From: Sue Howell
Sent: 12 June 2014 11:24
To: Cian Cronin
Subject: RE: Y/23/14/RES

From: Cian Cronin
Sent: 12 June 2014 11:12
To: Sue Howell
Subject: Y/23/14/RES

Your comments on this application (attached) mentioned you weren't satisfied with the proposed southern boundary hedge "gapping up" proposals.

PLANT SCHEDULE TO ID583.03

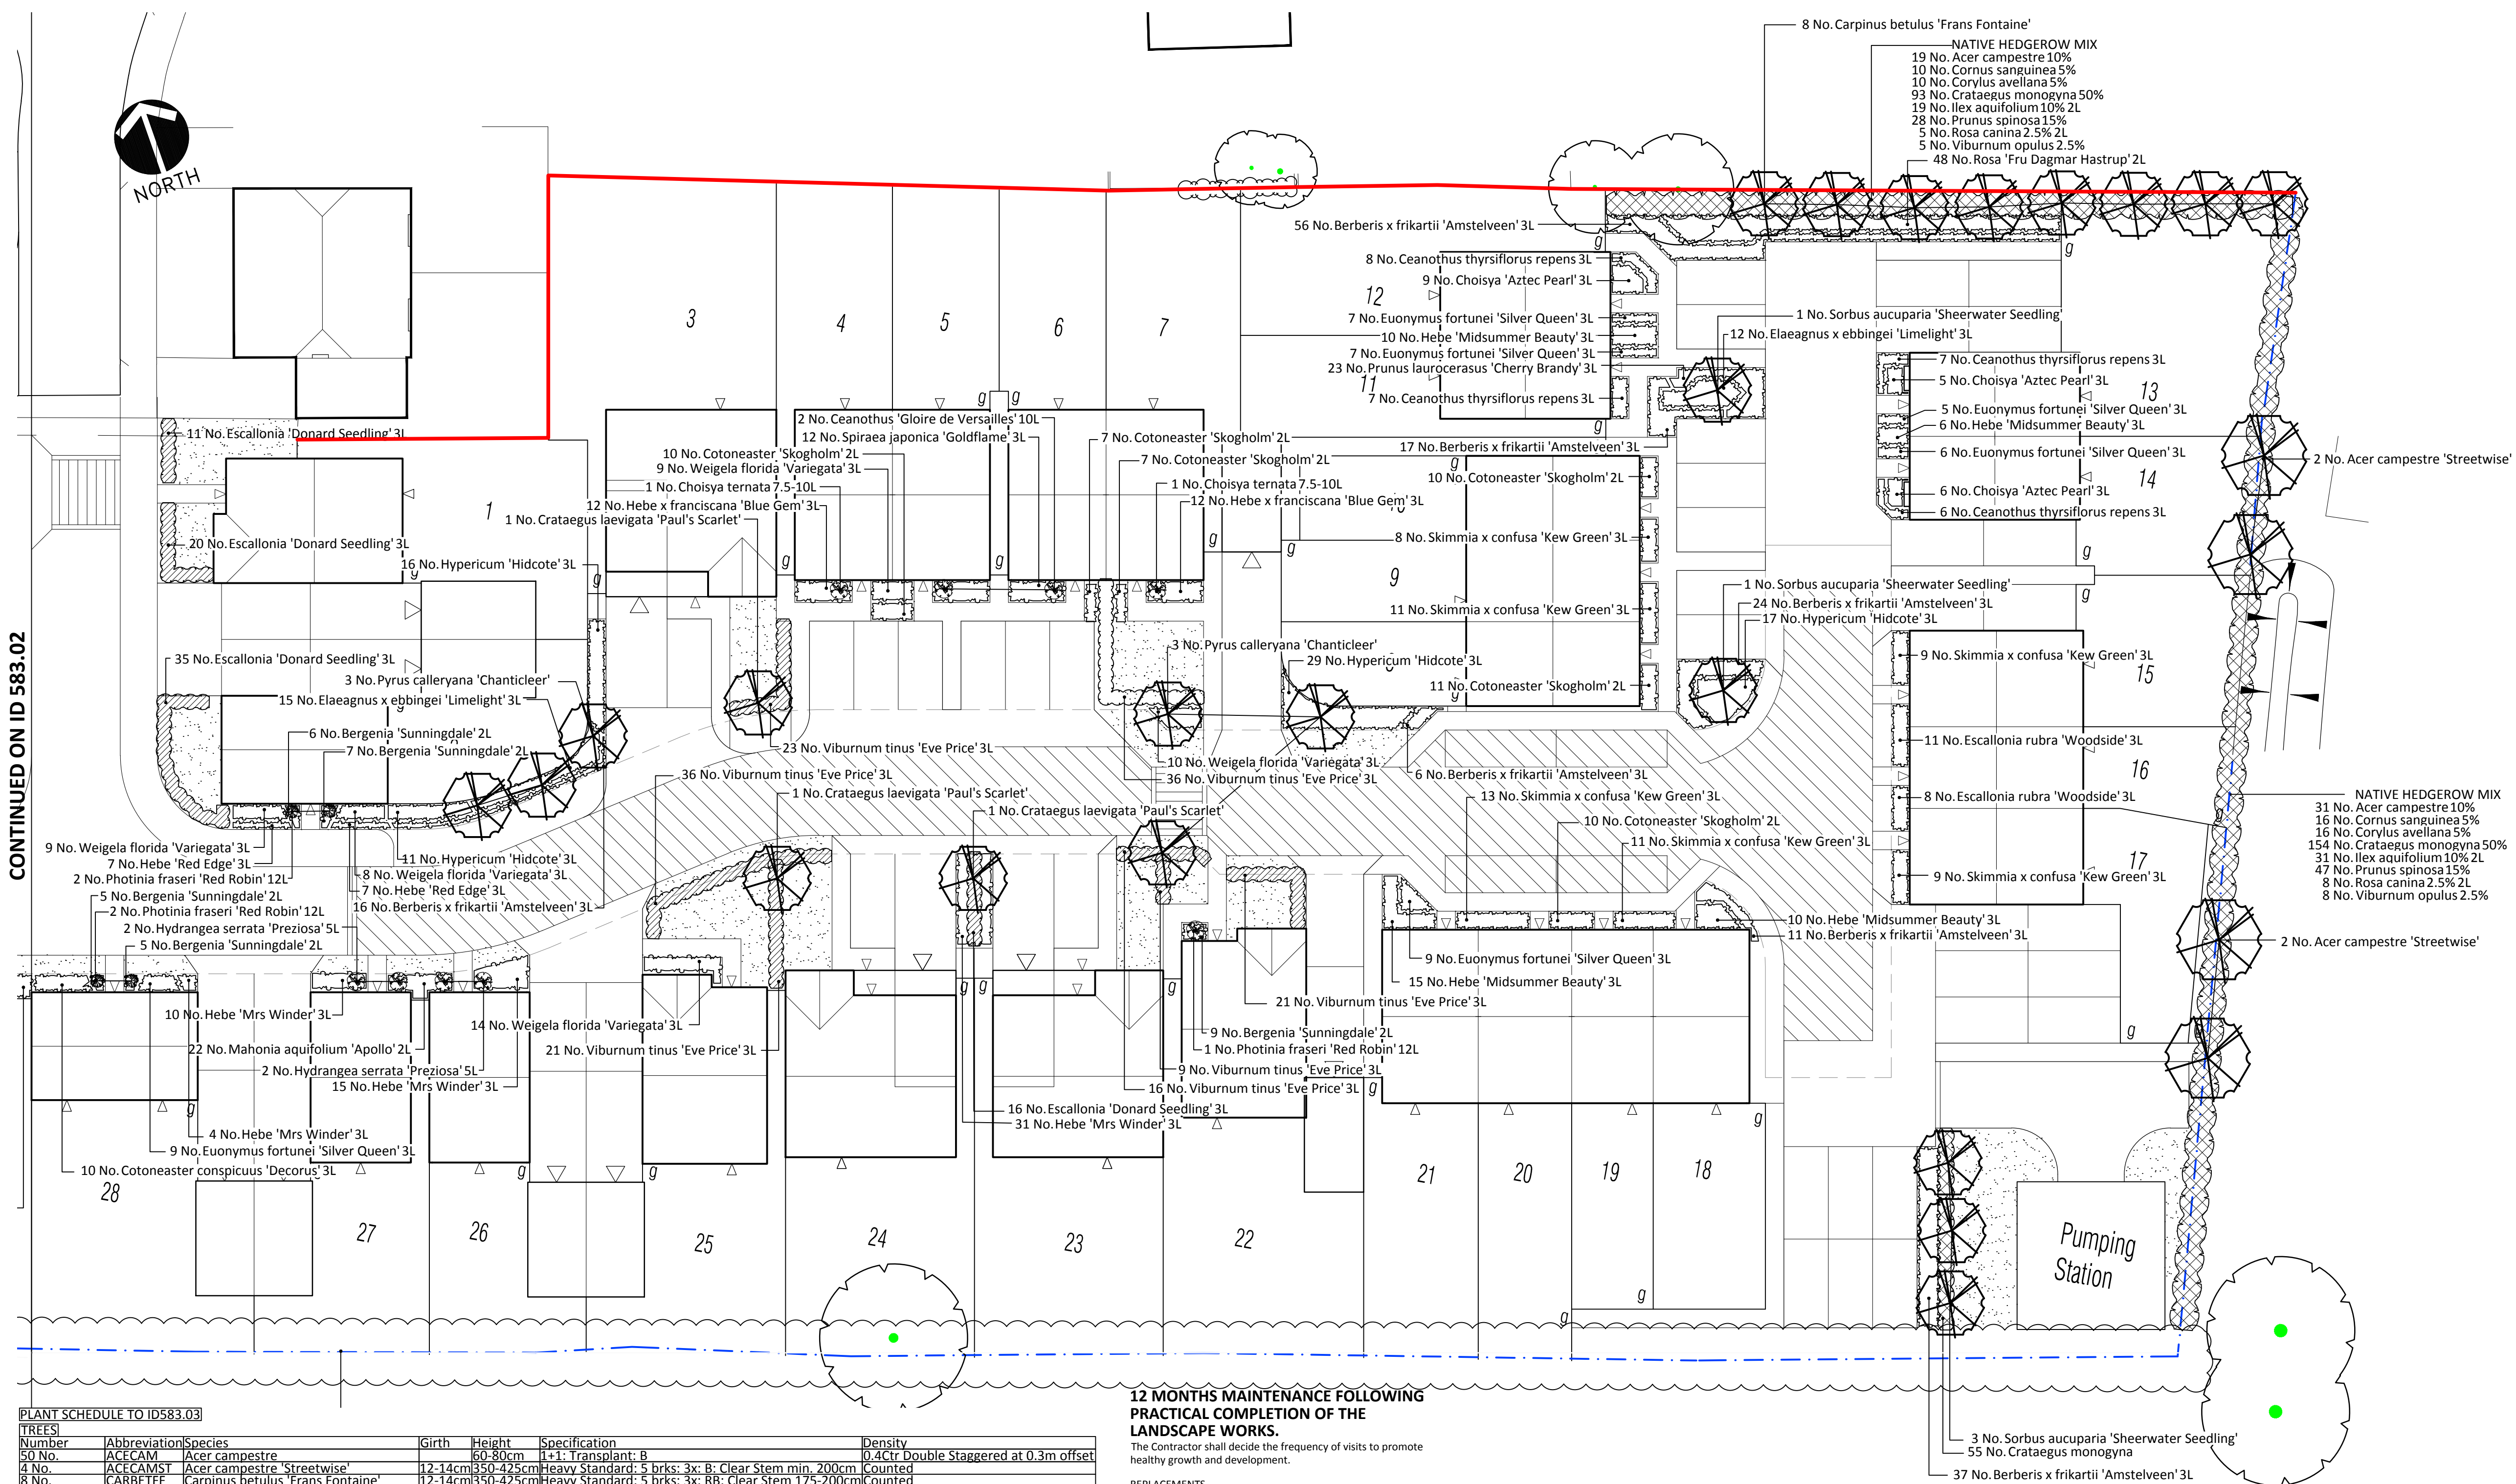
Just had a look at the plans and Yes the species mix and densities suggested are by far improved and these would now meet my approval to recommend the discharge of this condition.

The applicants have amended the scheme to take your comments into account.
